Andrew Beattie - Impact of Bypass on Berry Equestrian Centre

This submission concerns the impact of the proposed Foxground and Berry Bypass on the Berry Equestrian Centre which is located in North Street Berry.

The Issues Associated with the Design of the Proposed Relocation of the Berry Equestrian Centre

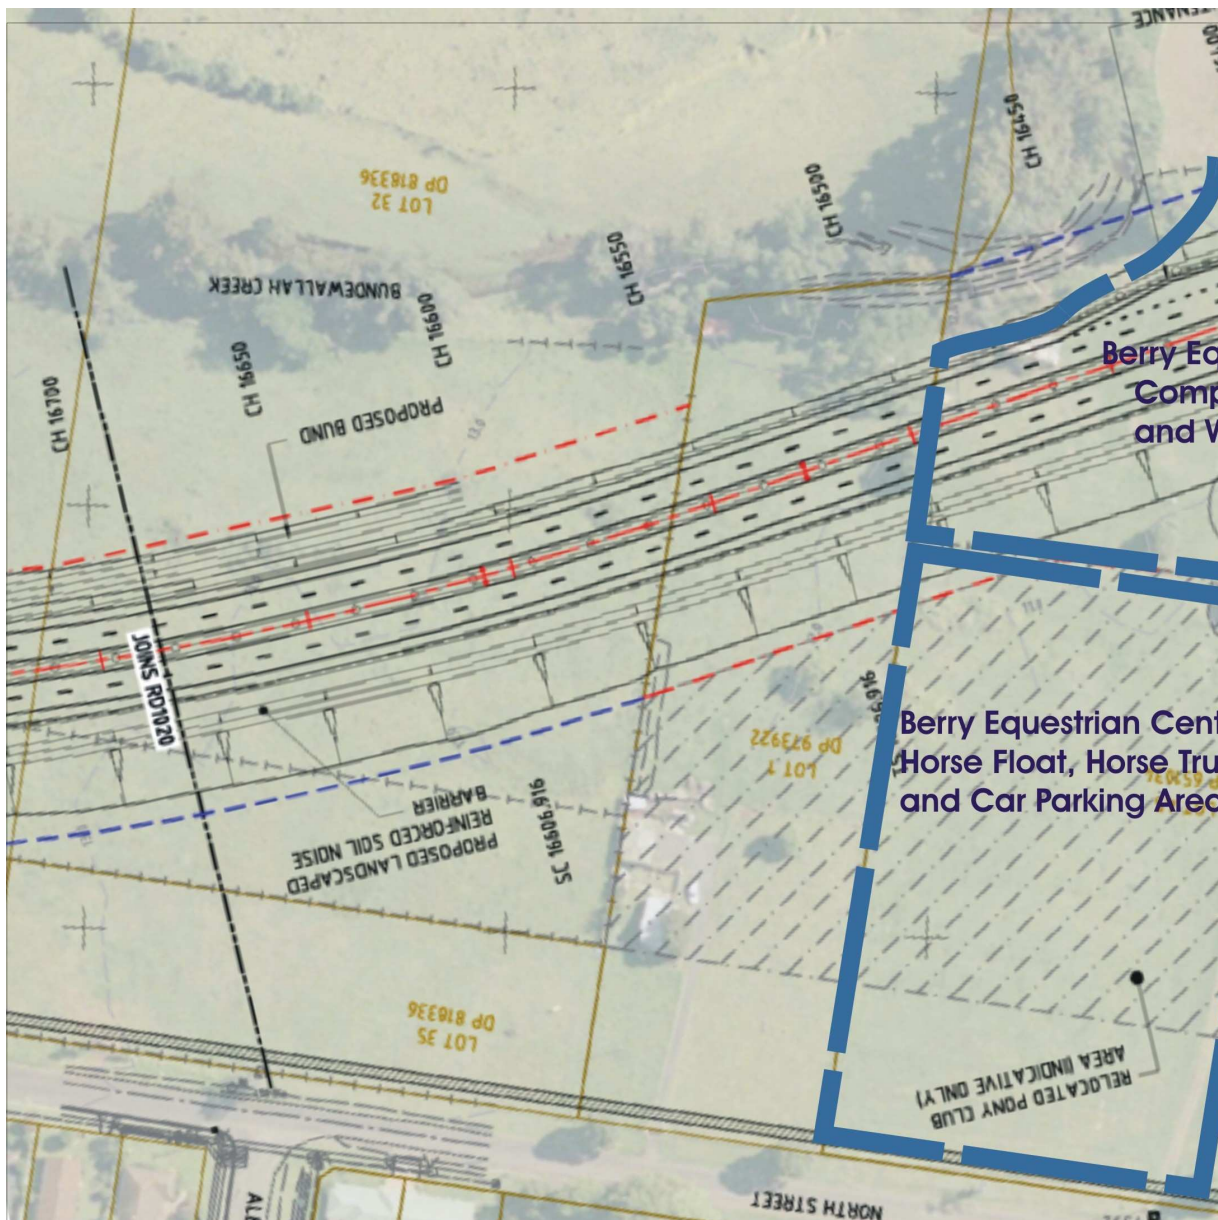
The design and loss of land of the proposed relocation of the Berry Equestrian Centre will have a significant impact on the ability to conduct events. It will impact riders, participants and spectators in the following ways.

1. The competition grounds are required to be rectangular /square in shape of a minimum size of 140 metres x 140 metres with a level, well drained, good riding surface in order to cater for at least 4 dressage arenas or 2 showjumping arenas.

2. The parking area is required to be of a minimum area equivalent to 90 metres x 160 metres and allow for easy entry, maneuverability, parking and exit of horse floats and trucks. Each parking space is equivalent to an absolute minimum of 4 normal vehicle spaces due to the need for unloading/loading and tie up areas for horses.

3. There is concern for the safety of horses, riders and the general public due to the near location of the proposed riding area to the 4 lane expressway, the skateway, the public cycleway/walkway and North Street. There will be anticipated significantly increased noise and visibility of cars and trucks travelling at 100km/hour on the expressway with horses competing nearby, often with young, very inexperienced riders.

4. Access to the grounds is likely to be across a public shared cycleway/pathway. The safety of children on skateboards, bicycles etc are at risk as horse trucks and floats cross the pathway. Horse floats and trucks also require an indented driveway of at least 15 metres to allow vehicles to park off the roadway whilst gates to the grounds are opened.
